# A1 Birtley to Coal House

## Scheme Number: TR010031

**Responses to Deadline 5 submission from other parties - Historic England - Appendix 2A - Consultation with Lee McFarlane, Historic England**

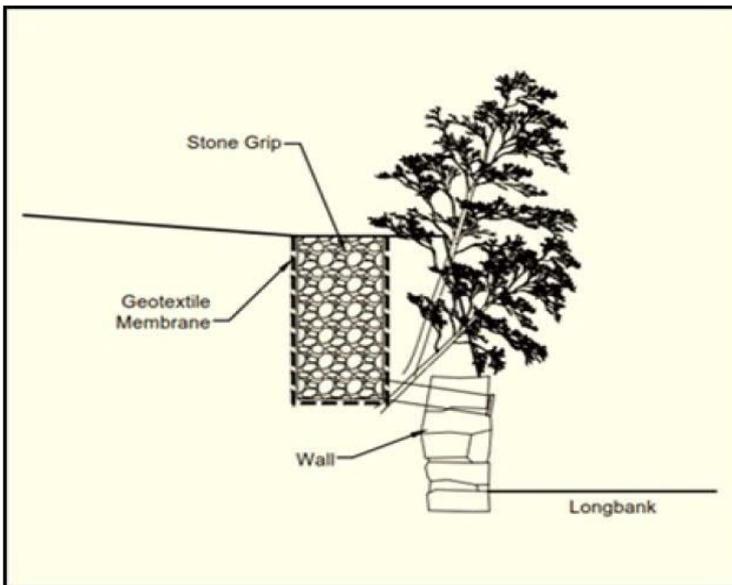
Regarding the drainage drawing below. Does it show the grip being near the top of the wall? I would worry that there is potential for water damage down the face of the wall (and ultimately cause mortar loss/water ingress into the structure) if it is this high up? Could it be lower perhaps?
